**KIRKLEES METROPOLITAN COUNCIL
INVESTMENT & REGENERATION SERVICE**

DELEGATED DECISION TO DETERMINE PLANNING APPLICATIONS

Reference No:	2022/62/92837/W
Site Address:	44, Oaklands Drive, Dalton, Huddersfield, HD5 8PR
Description:	Erection of first floor side extension
Recommending Officer:	Tom Hunt

DECISION – REFUSED

Appendix 3: Proposed Development Plan

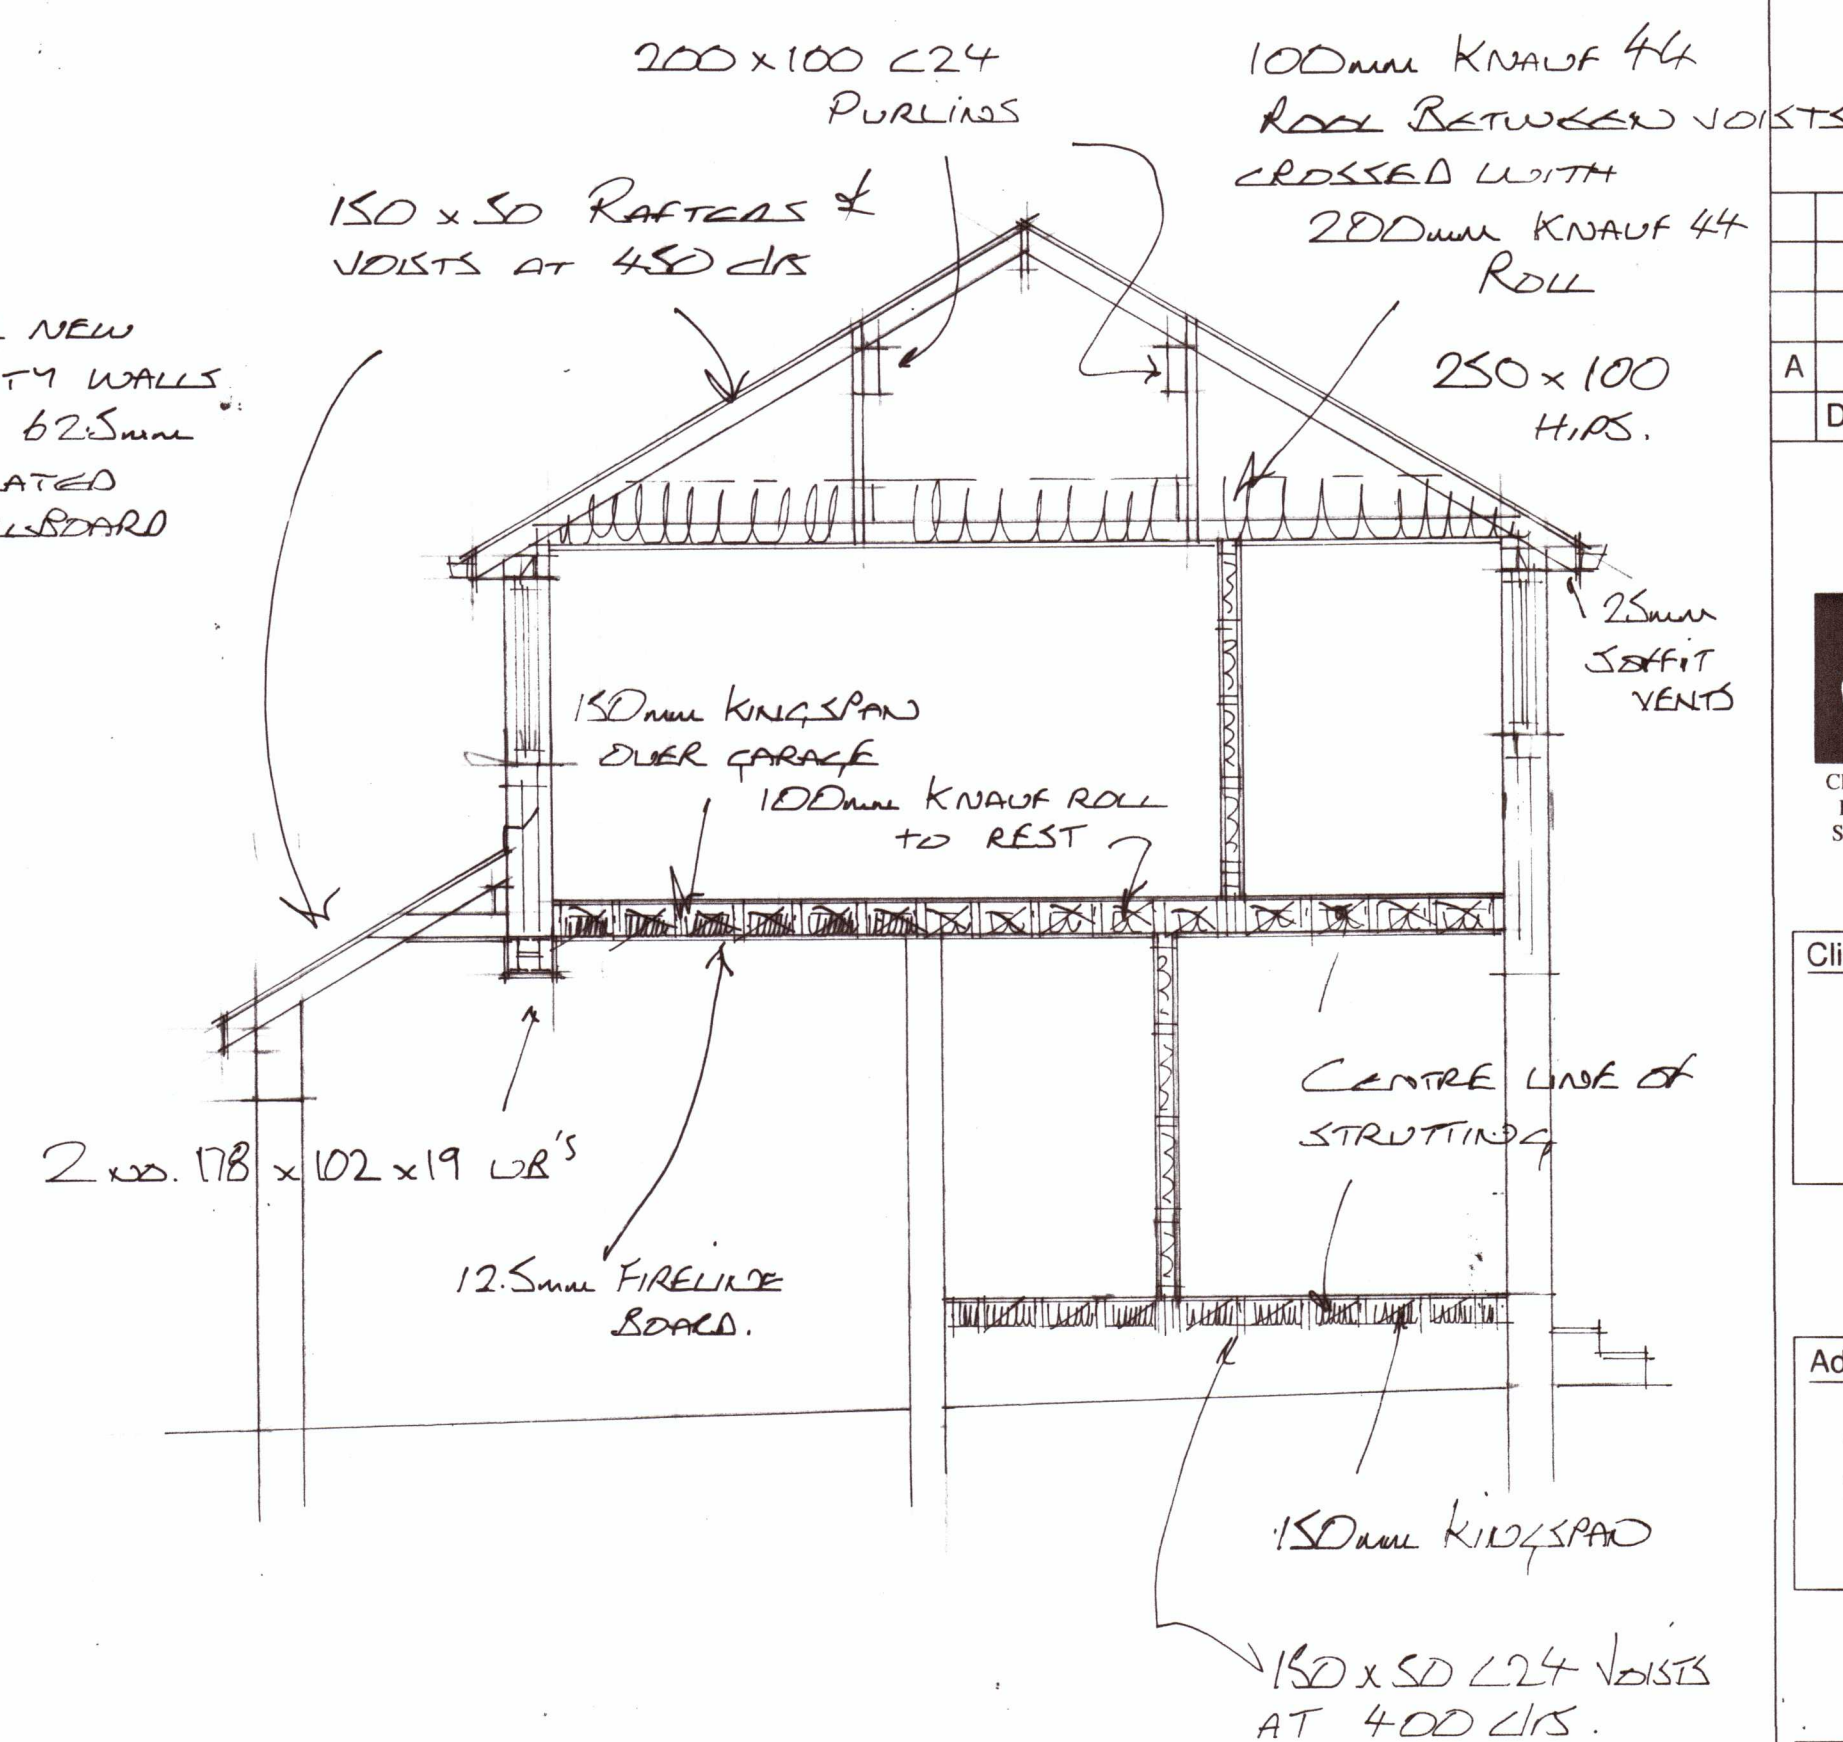
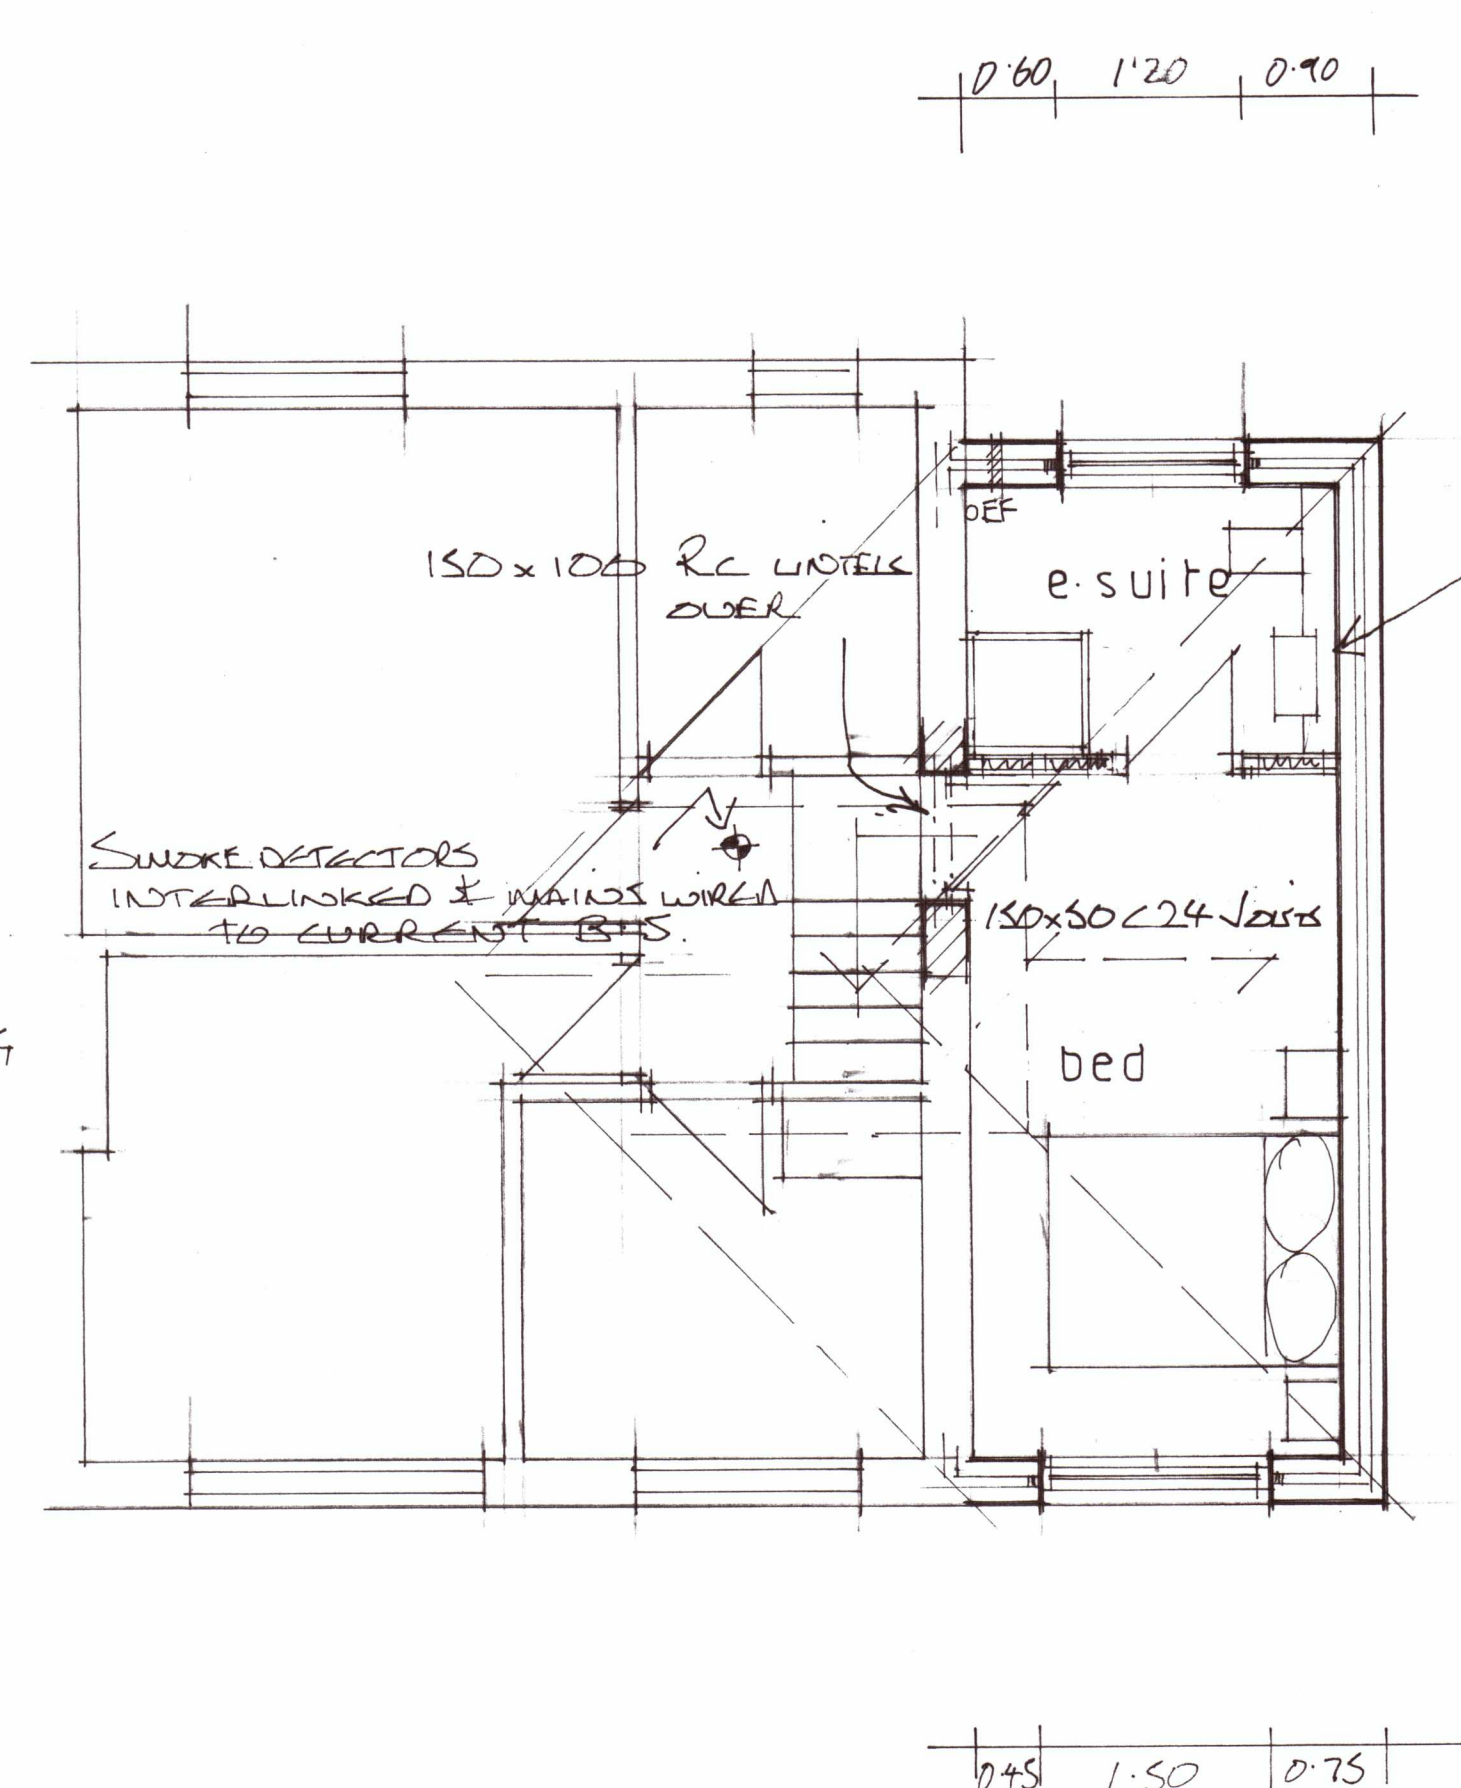
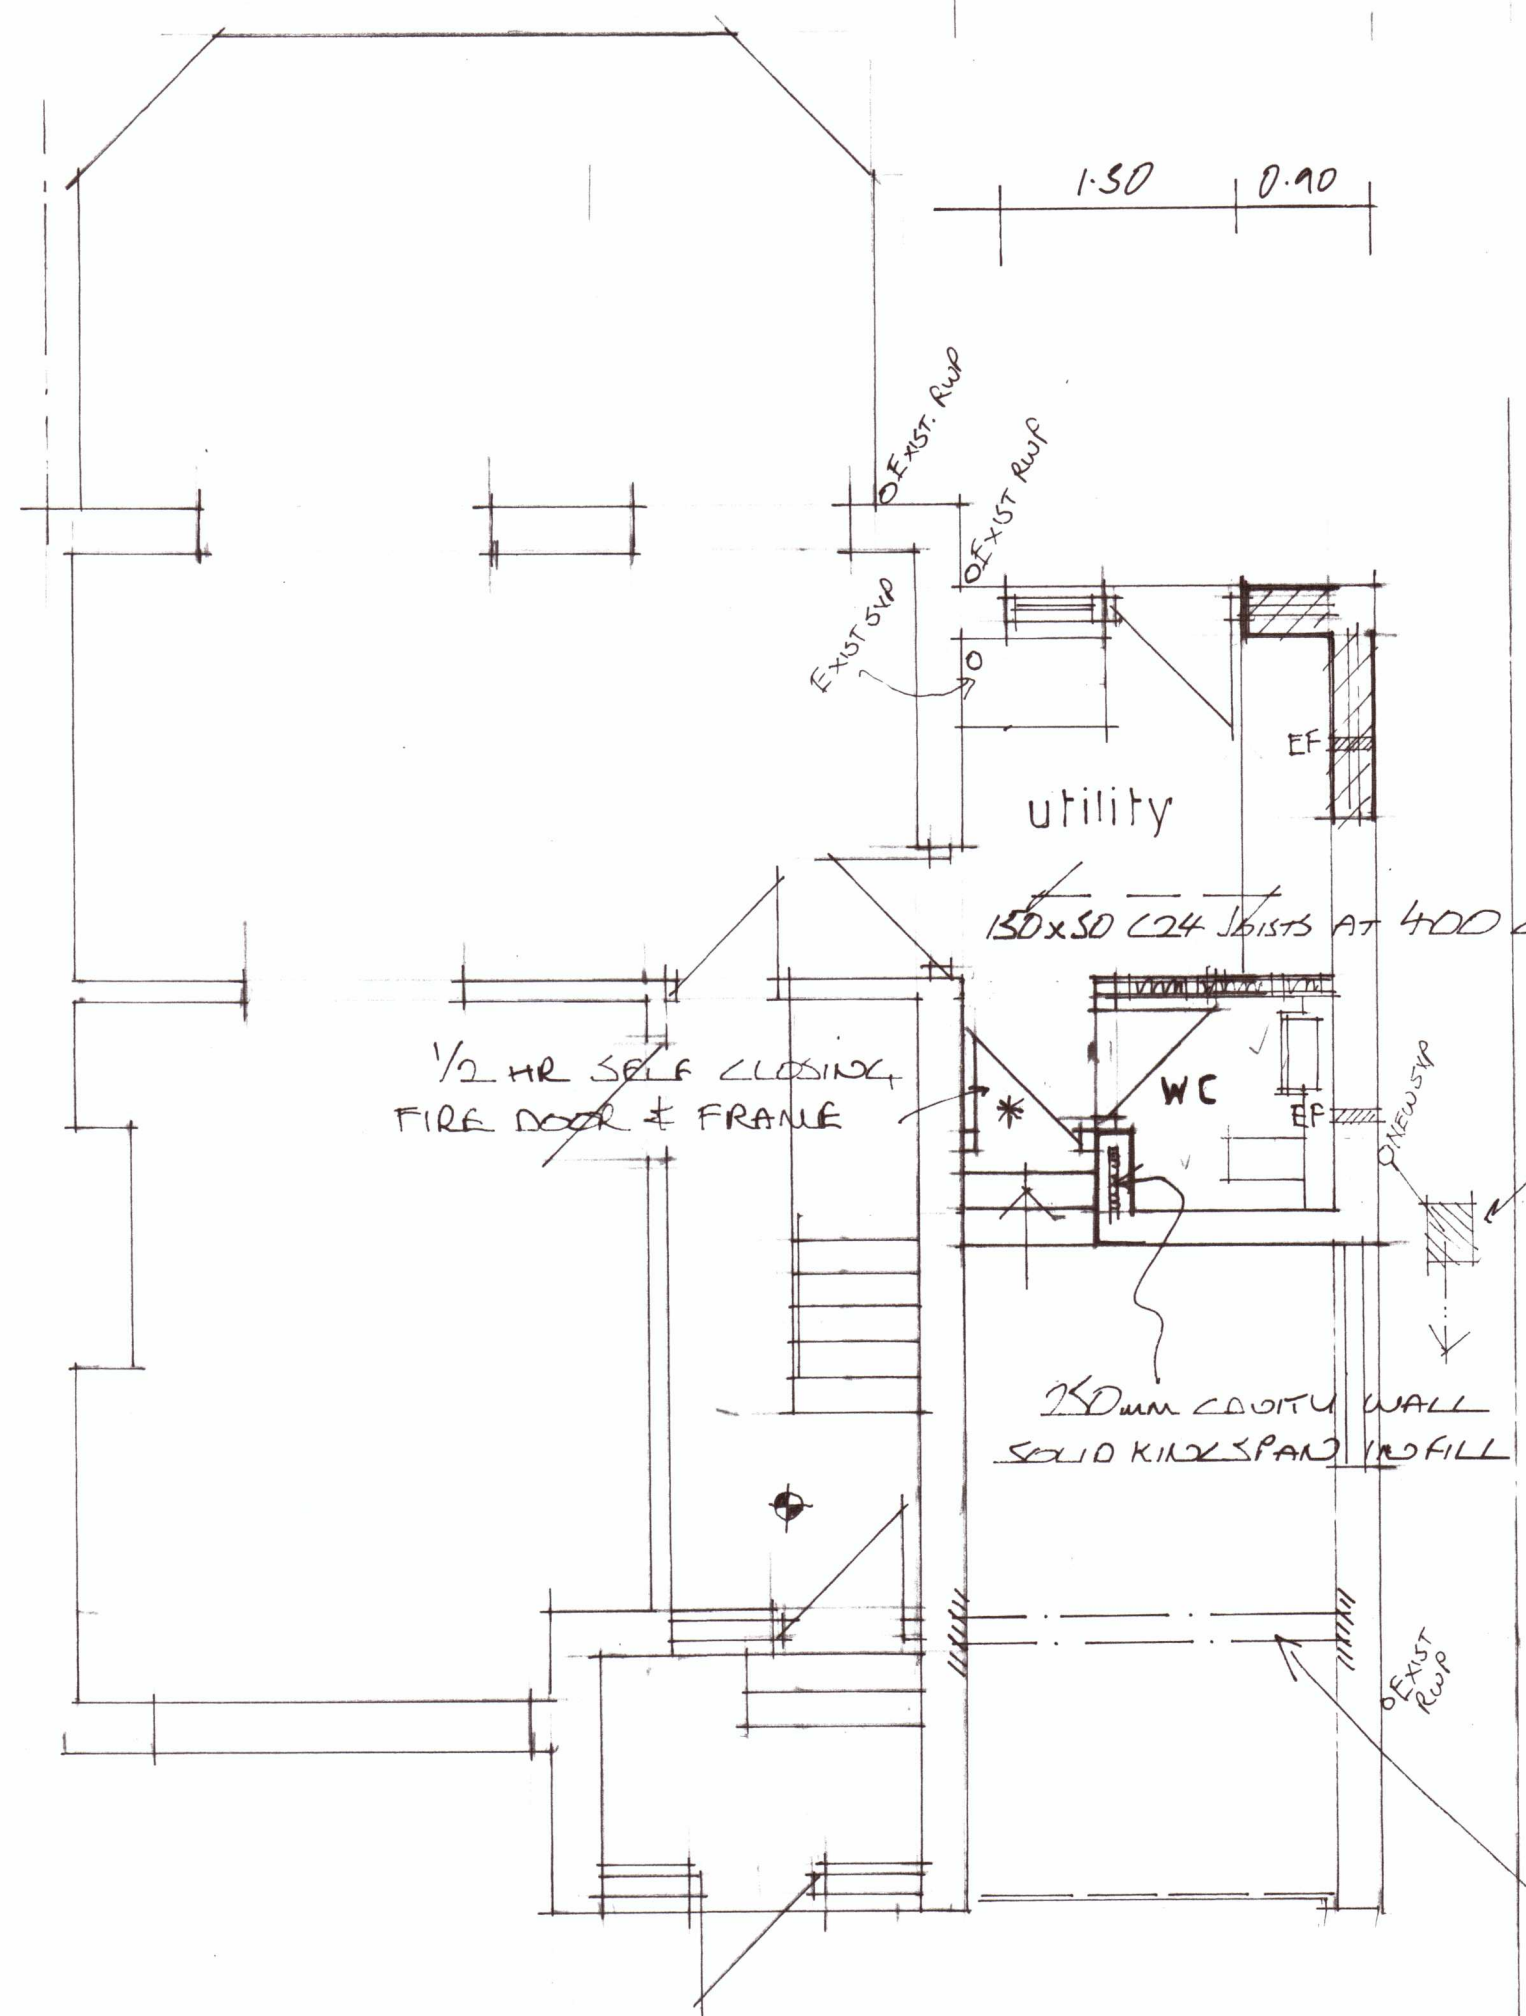
The proposed development would be over an existing single-storey side extension with an existing 0.8m gap to the boundary and be closely adjacent to no. 42's existing flat roof single-storey side extension. It would have its front elevation and front roof plane flush with the host's own, with some of its bulk slightly reduced by a set down roof ridge height. This bulk and massing to the fore, close to the neighbour and thus closing the property gap, would appear to contribute to a significant loss of openness between those neighbours and increase the risk of harmful terracing, should the neighbour wish to extend similarly. Cumulatively with the new lean-to roof design at front, the proposal would create a visually dominant and overbearing addition to the host.

As such, it would appear prominent and contrary to the existing established local character and openness in the streetscene of semi-detached properties with single-storey side extensions. Other examples of similar side extensions have been set back or have flush extensions that are not closely adjacent to neighbouring properties to ensure that the openness between properties is retained and so Officers concur that the proposal would contribute to a harmful loss of openness to the local character of the area contrary to Key Design Principle 1.

The proposed first floor side extension, by reason of its size and location close to the shared boundary, would result in loss of outlook and form an overbearing impact in relation to the first floor southeast window of the adjacent dwelling, no. 42. To permit the extension would have a detrimental impact on the residential amenity of the occupants of no. 42 and would be contrary to Policy LP24 of the Kirklees Local Plan, KDP5 and KDP6 of the House Extensions and Alterations SPD and advice within chapter 12 of the National Planning Policy Framework.

1. The proposed side extension, by reason of its design, would form an extension which is not subservient and would form an incongruous feature. To permit the proposals would be contrary to Policy LP24 of the Kirklees Local Plan, Key Design Principles 1 and 2 of the House Extensions & Alterations SPD and policies within Chapter 12 of the National Planning Policy Framework.

The case officer considered the application on review and requested amendments to the design to comply with the House Extensions and Alterations SPD. Specifically setting the first floor extension back 0.5m to achieve a more subservient design.
